**RE: Main Event, Albuquerque Carpenters Training Center, Pan American Freeway  
and Vassar Drive  
Grading Plan and Drainage Plan  
Engineer's Stamp Date 5-14-2015 (File: G16-D149)**

May 8, 2015

**RE: MAIN EVENT,  
PAN AMERICAN FREEWAY AND VASSAR DRIVE  
GRADING PLAN AND DRAINAGE PLAN  
ENGINEER'S STAMP DATE 3-27-2015 (FILE:G-D149)**

MAIN EVENT		DRAWN BY
PAN AM FREEWAY AND VASSAR AV.		BJF
GRADING PLAN		DATE
		05/14/15
		2015015_GRB
		SHEET #
		C5
		JOB #
		2015015

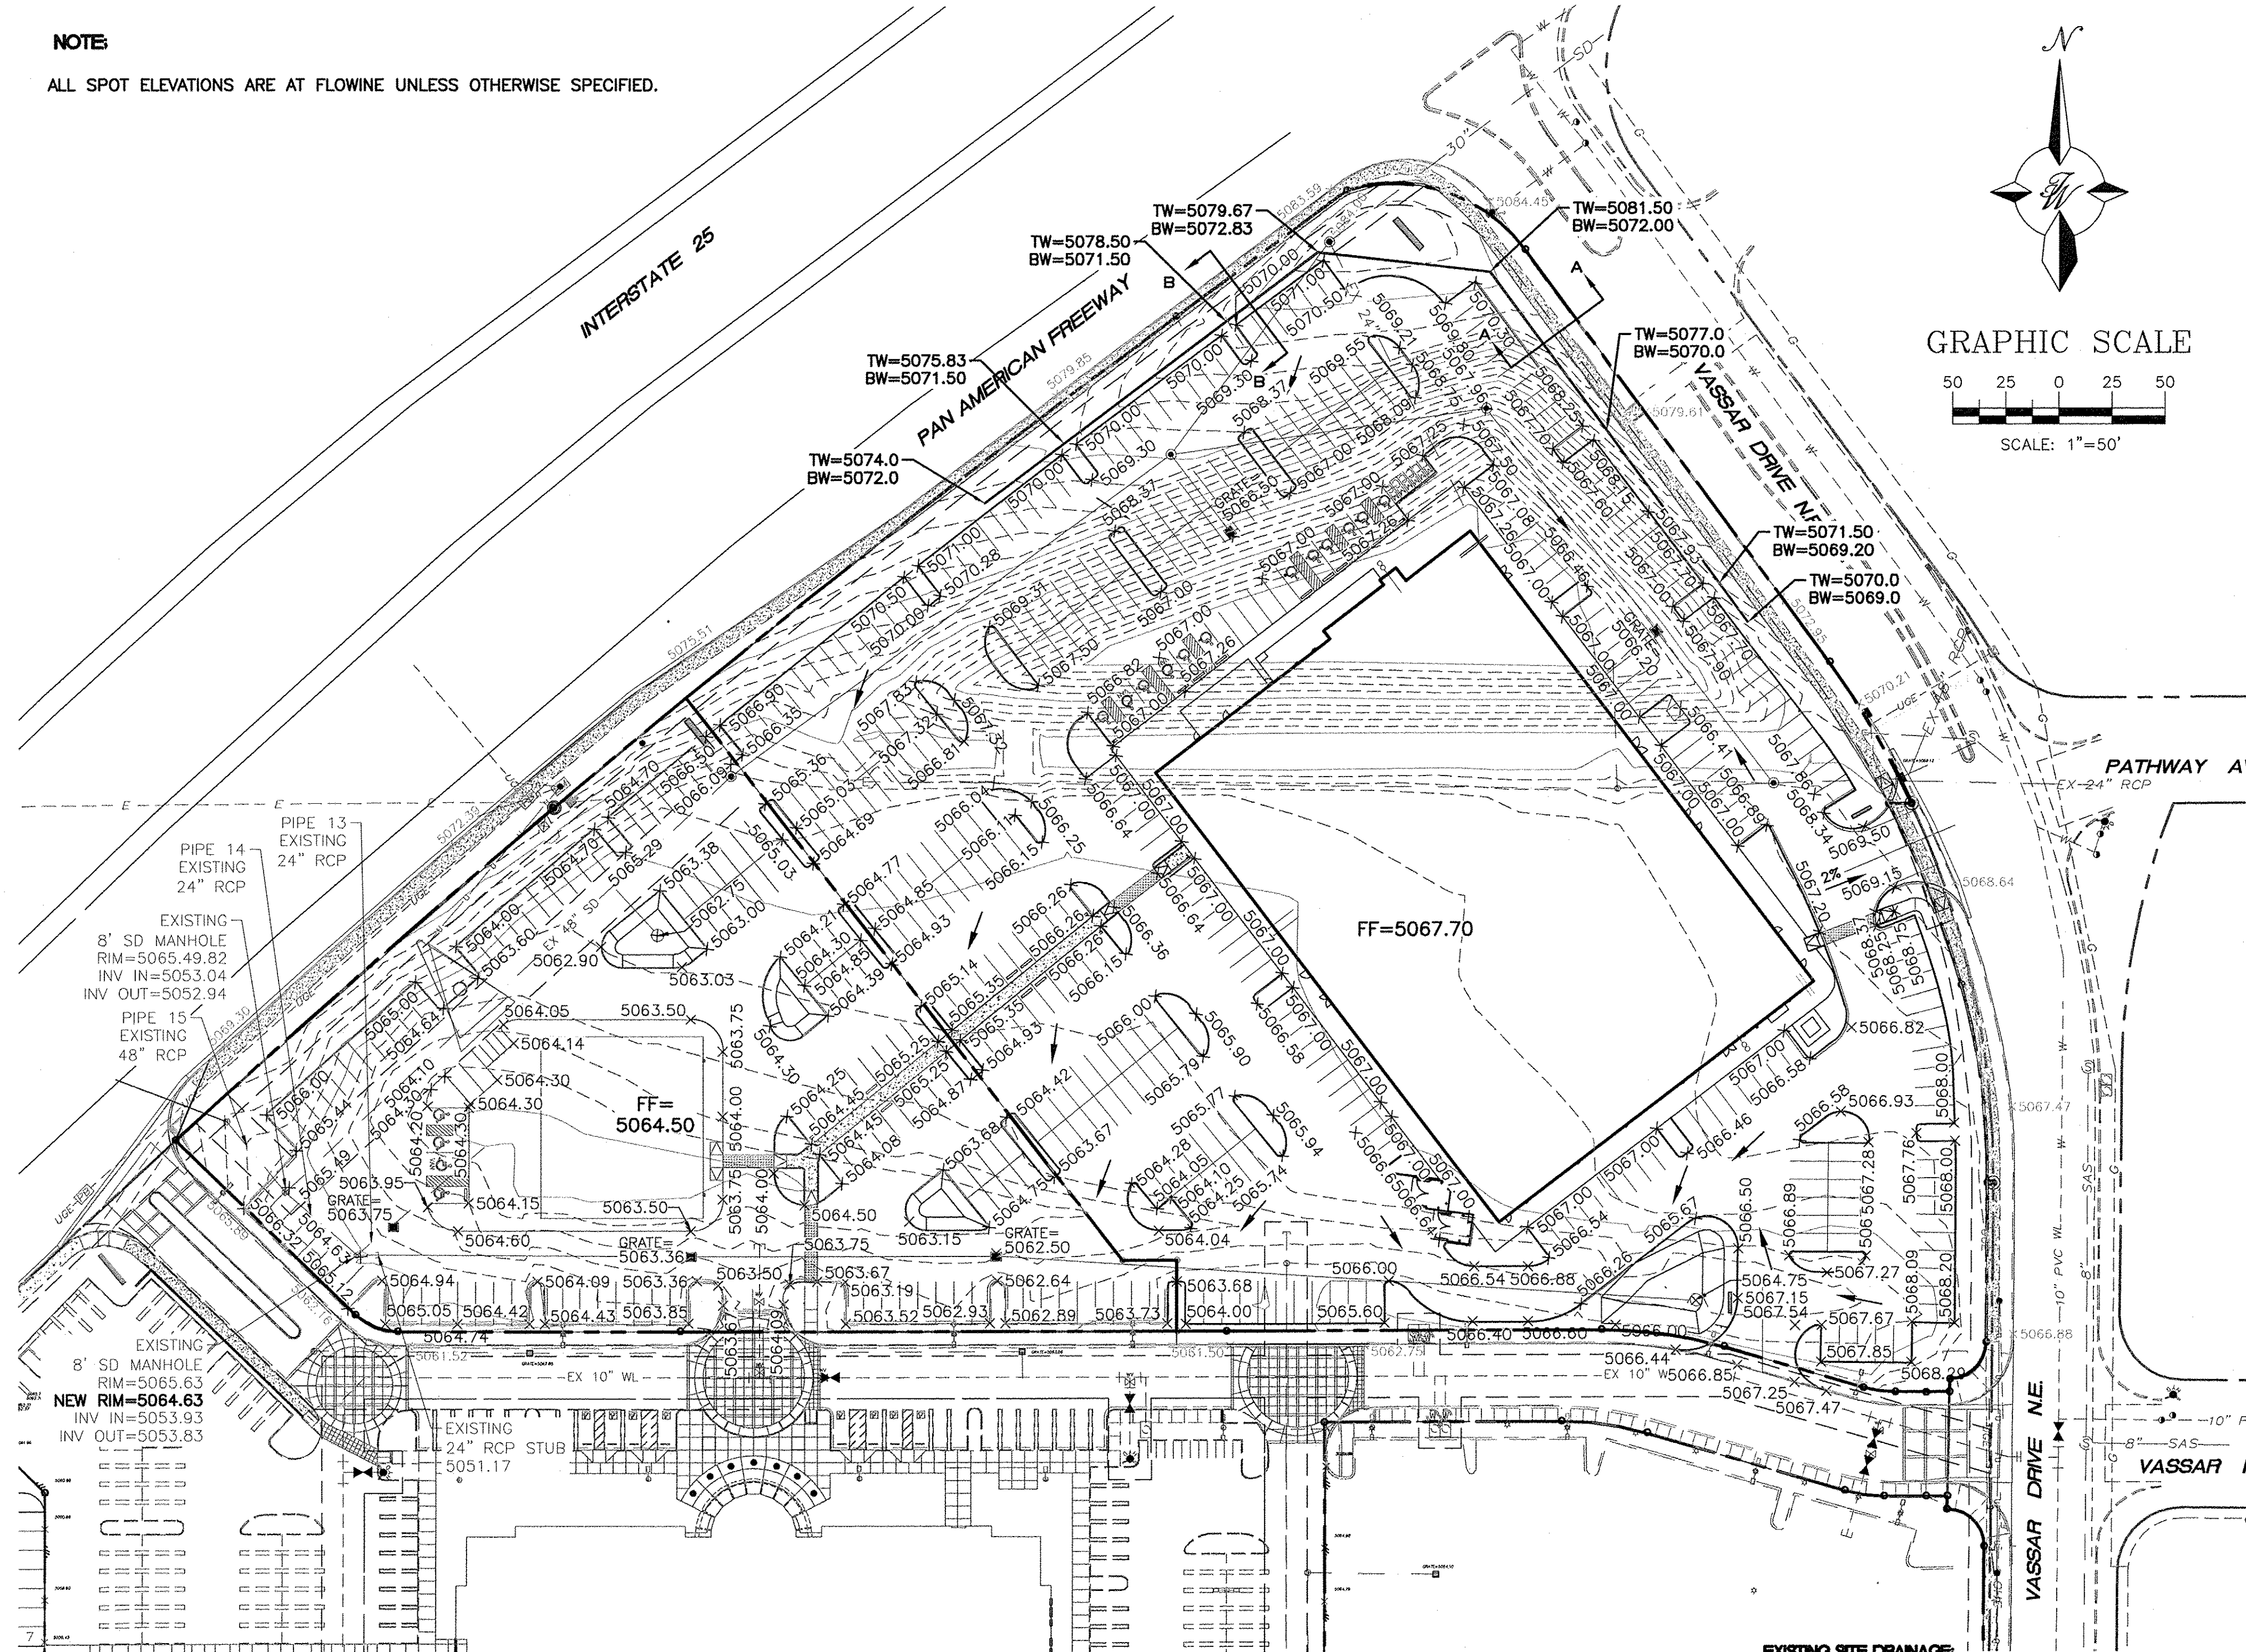
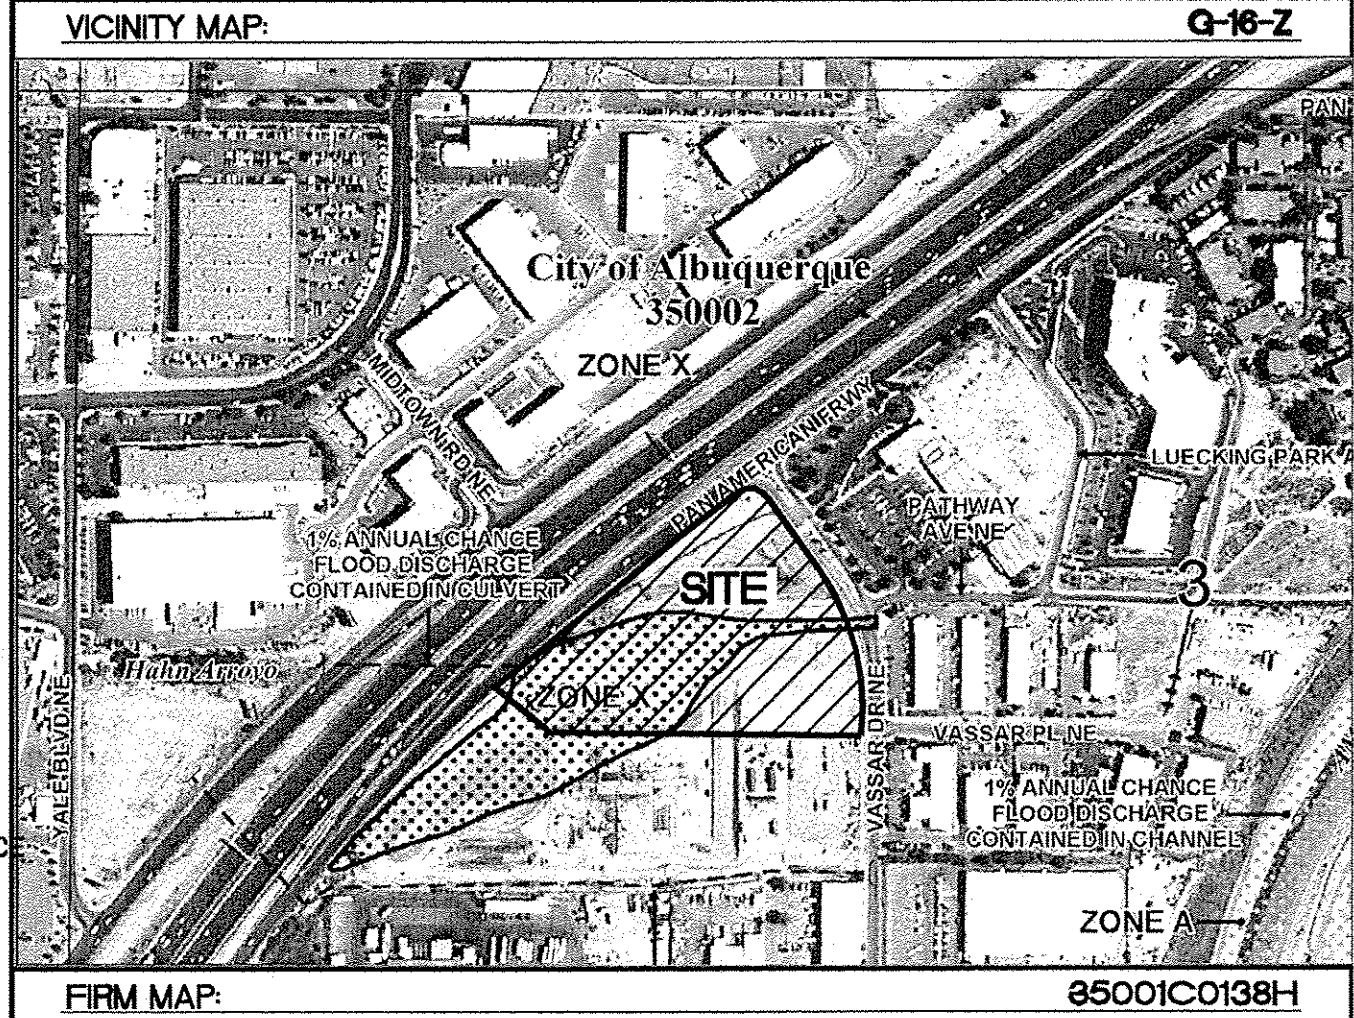
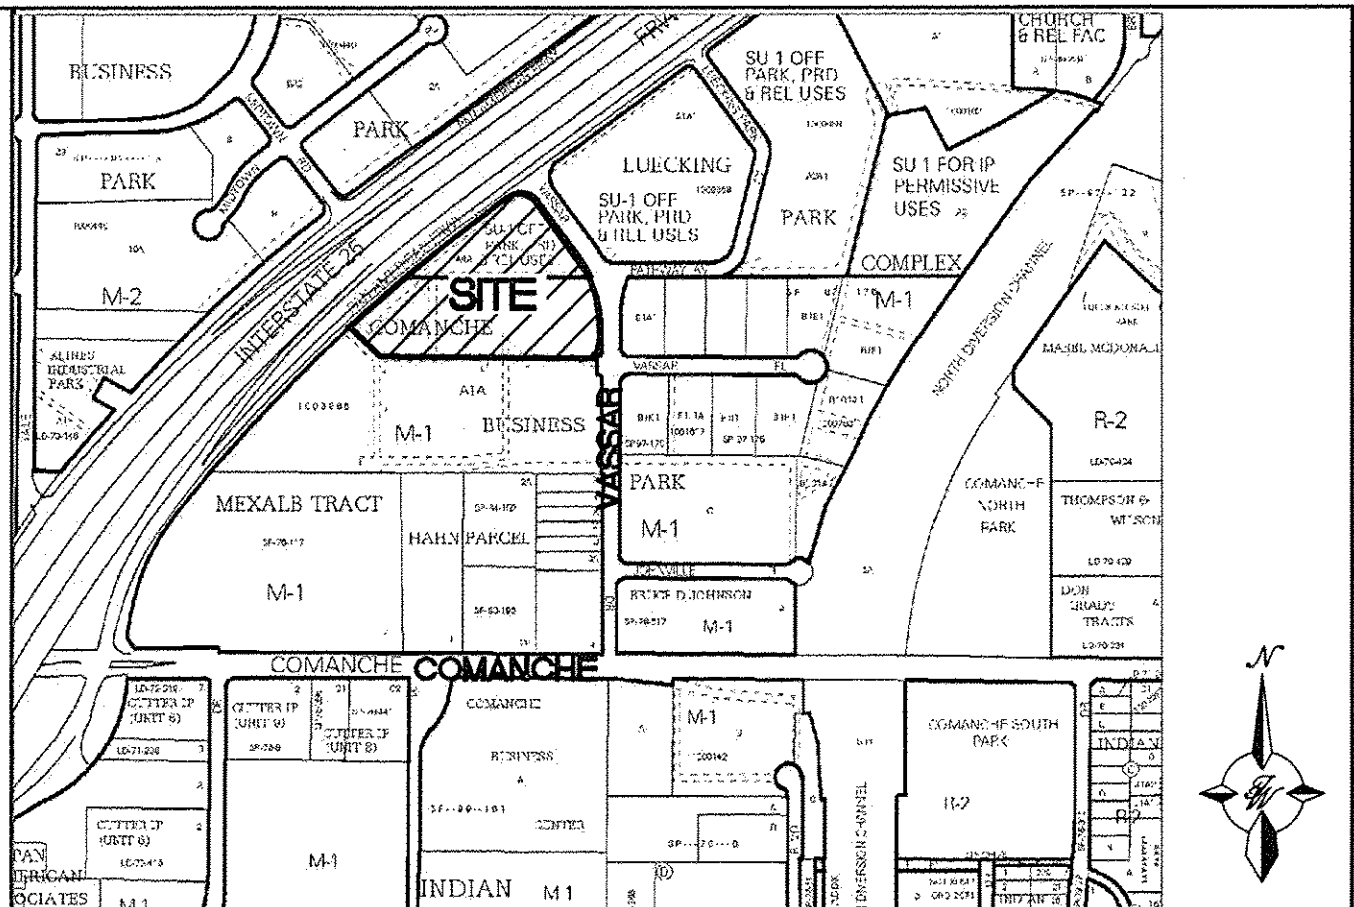
5. Check the middle entrance to the private drive south of the building with regard to grade elevations. A couple of new spot elevations are shown to be 3 feet off from existing spot elevations, creating a very steep drop. Include more existing spot elevations within the public and private roads surrounding the site. **There is no middle entrance. The existing entrance is being eliminated. A note was added to show that we are adding curb and gutter in this location to make it clearer.**

7. It looks like an approximate 3:1 slope is being crated between the Pan American Freeway and the retaining wall along the parking lot. Provide Section A-A symbol on the plan view. There is an elevation discrepancy where the top of wall elevation is 5079.67, and there is an existing 5084.0 spot elevation as well as a 5086.90 for new manhole rim elevation within very short distance from the wall. **Section A-A was already shown for the cross-section on Vassar Drive so Section B-B was added on Sheet C5. The manhole rim elevation was corrected.**

9. Specify elevations in parking lot to be at bottom of curb if this is the case. **A note was added to the Grading Plan stating that all spot elevations are at flow line unless otherwise specified.**
